From: Michael Eastham <Michael.Eastham@arun.gov.uk>
Sent: 26 May 2021 13:03
To: Planning.Responses <Planning.Responses@arun.gov.uk>
Subject: FW: BE/61/21/DOC Condition 8 - Salt Box

Please upload onto Ocella the email below which is from the **applicant** clarifying the situation regarding **Condition 8** of discharge of condition application **BE/61/21/DOC**.

Full application Condition 8 - Unit 2 Cycle storage

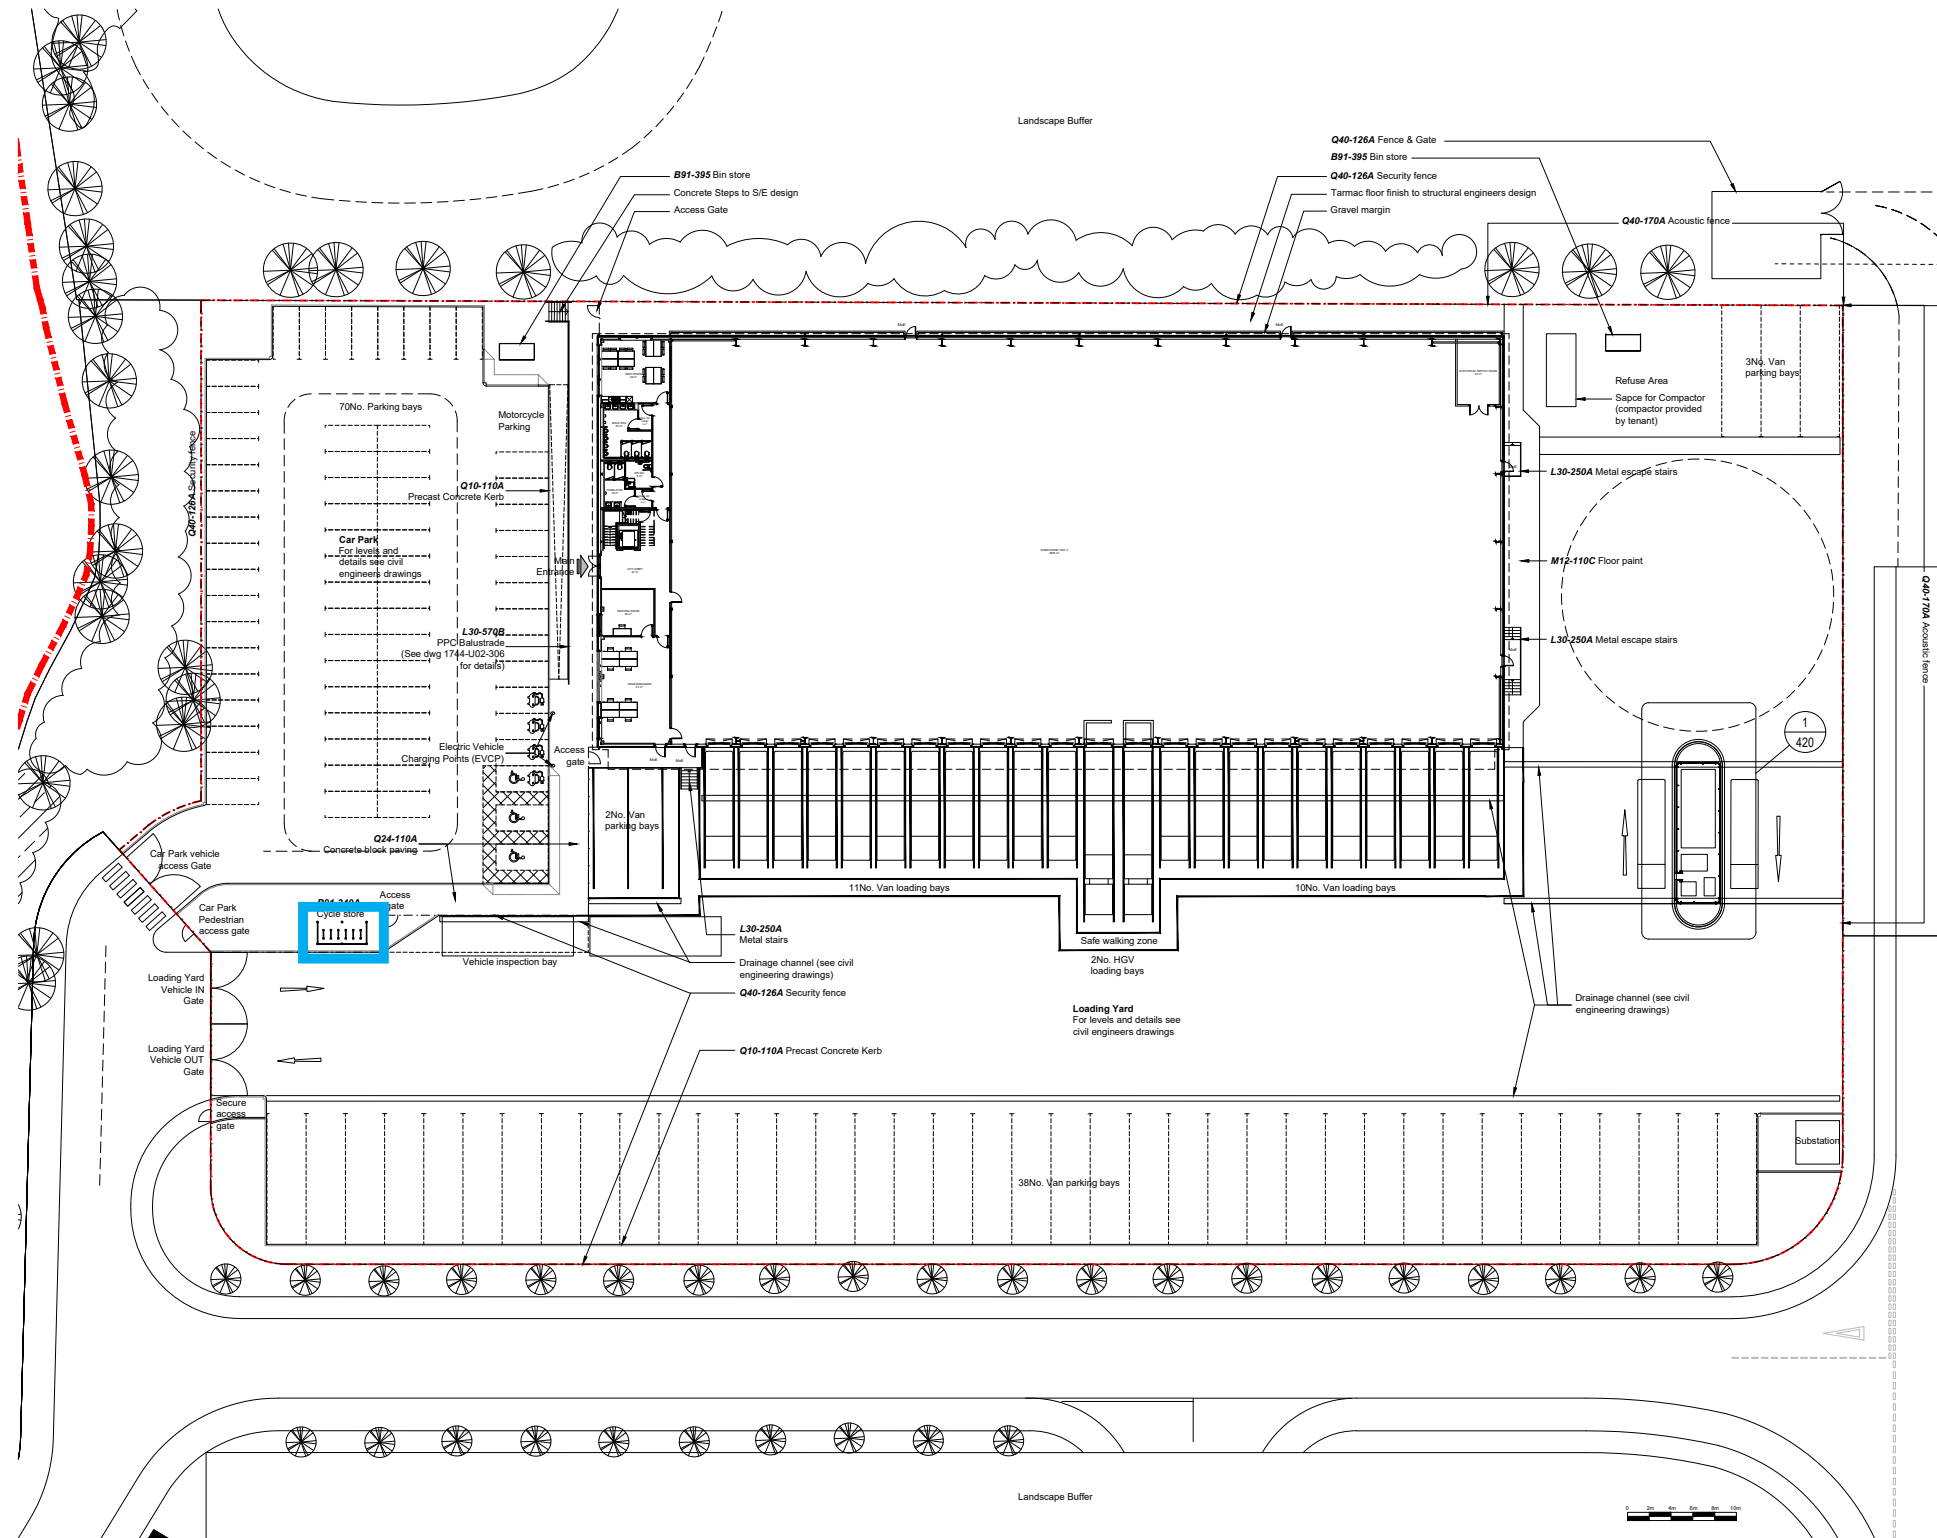
Condition 8 requires 'covered and secure' cycle parking spaces. Some of them appear to be open hoops which are not covered.

Please could you submit amended plans showing 'covered and secure' cycle parking spaces for Units 2, 4, 5 and 8.

Under the previous planning application (we submitted the attached (1744-PGG-09) under condition 13, for unit 2 showing the cycle shelter, which can hold 12No. bikes, which is also in line with the transport statement submitted and is in line with WSCC requirements. Approval letter attached.

Full application Condition 8 - Units 4,5 & 8 Cycle storage

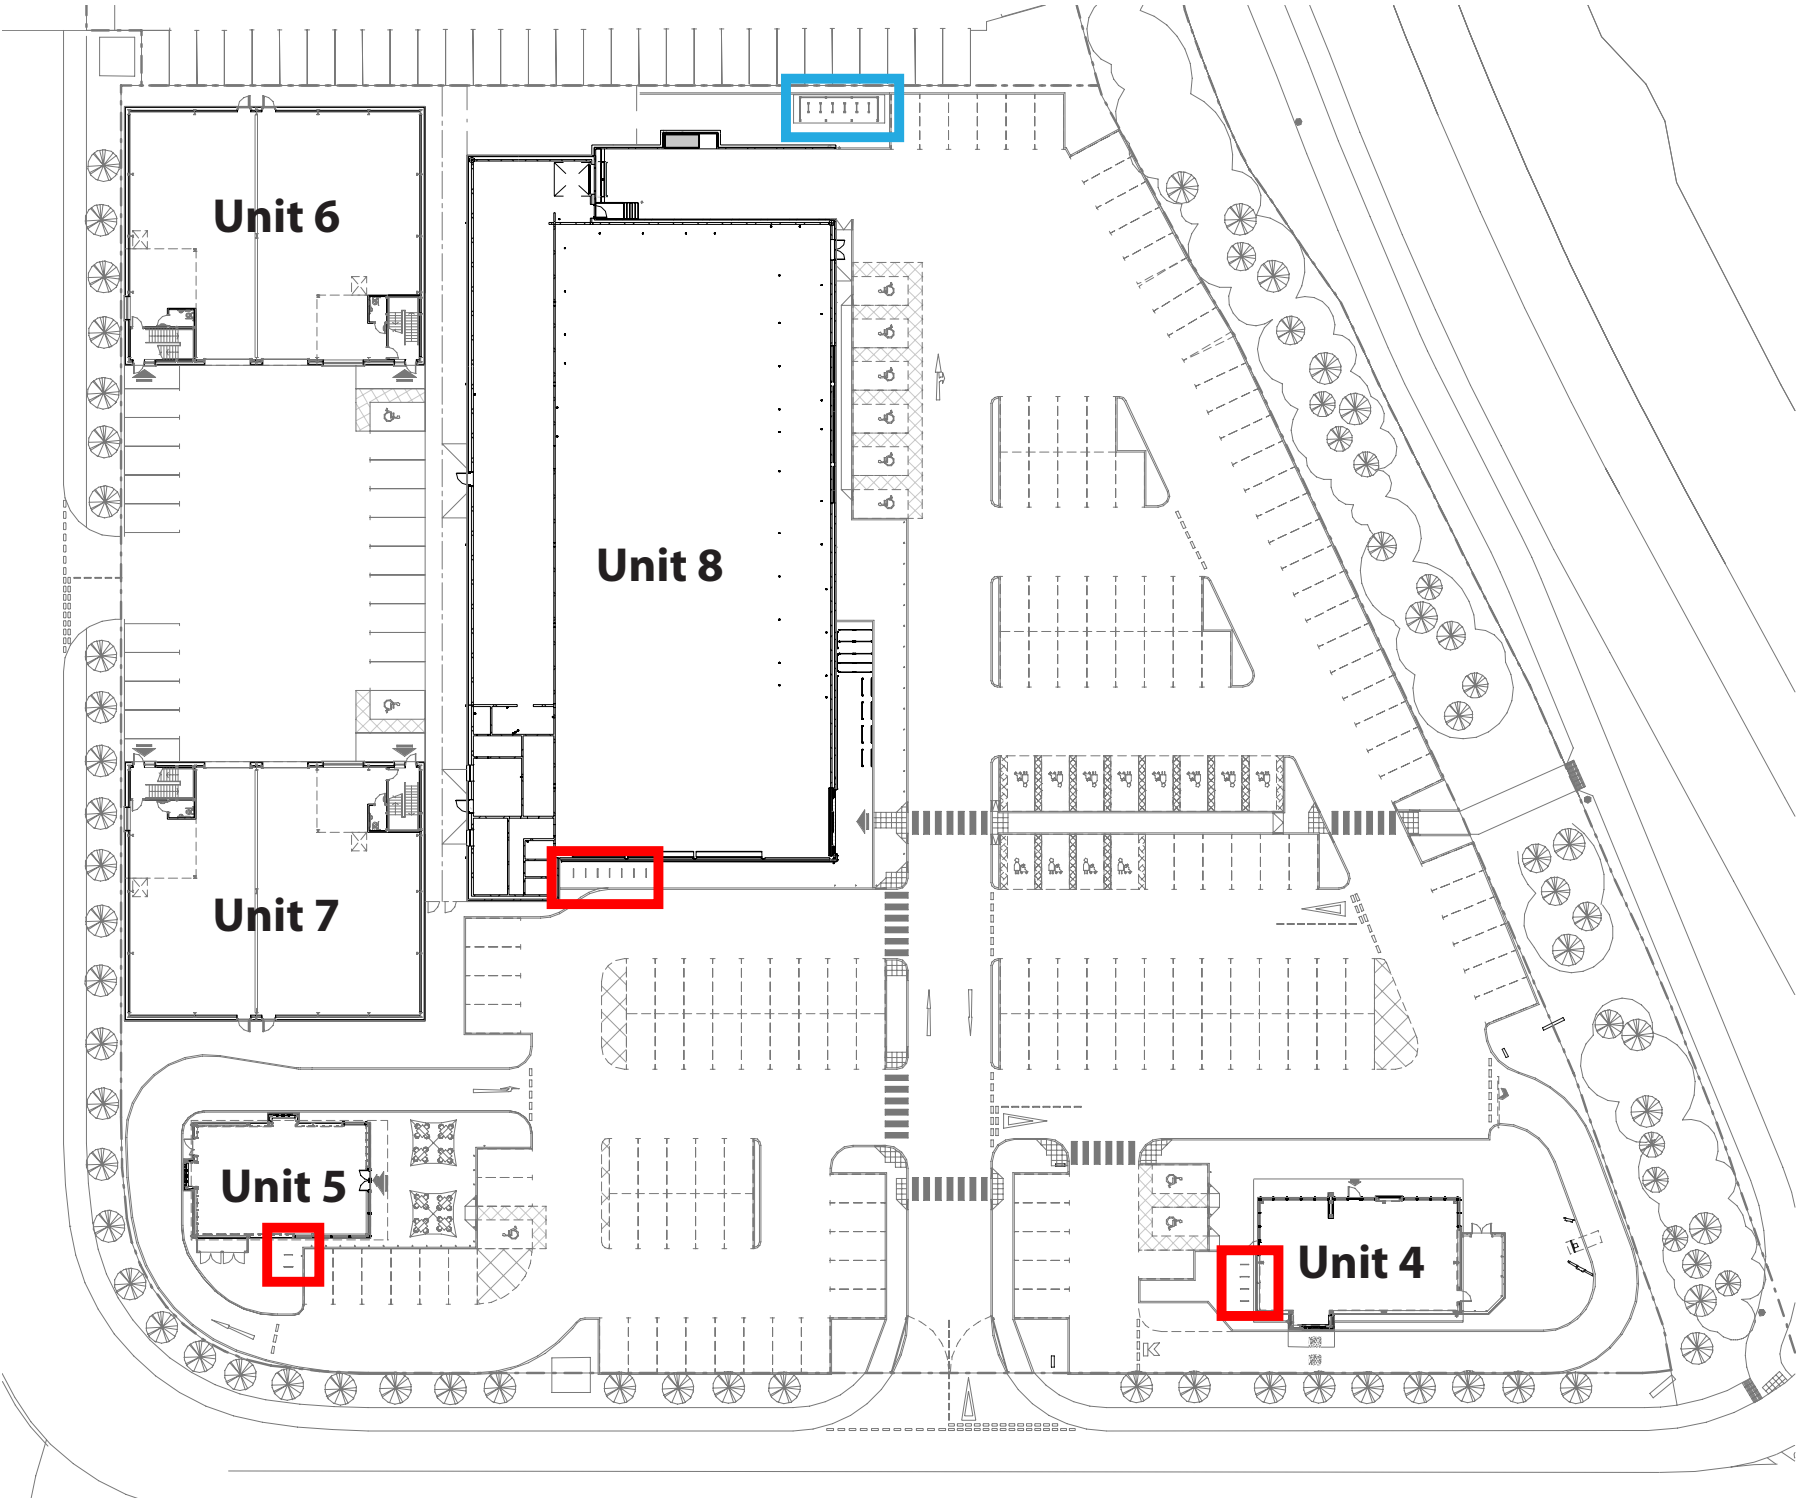
Could you also confirm that the number of spaces meets the Arun Parking Standards SPD requirements.

For Full Condition 10, what we submitted clearly shows the types of cycle parking, the overall number (38No. which is in line with the transport statement, and WSCC requirements, for these buildings (4,5 & 8)) and where they are located. This condition was approved, and therefore we have continued the hard landscaping (which is now very well advanced) and cycle storage in line with this approval (see discharge letter attached).

In any case the only spaces which are truly un-covered are those for Greggs and Starbucks, as the Aldi spaces are either in a purpose built shelter or under their canopy return.
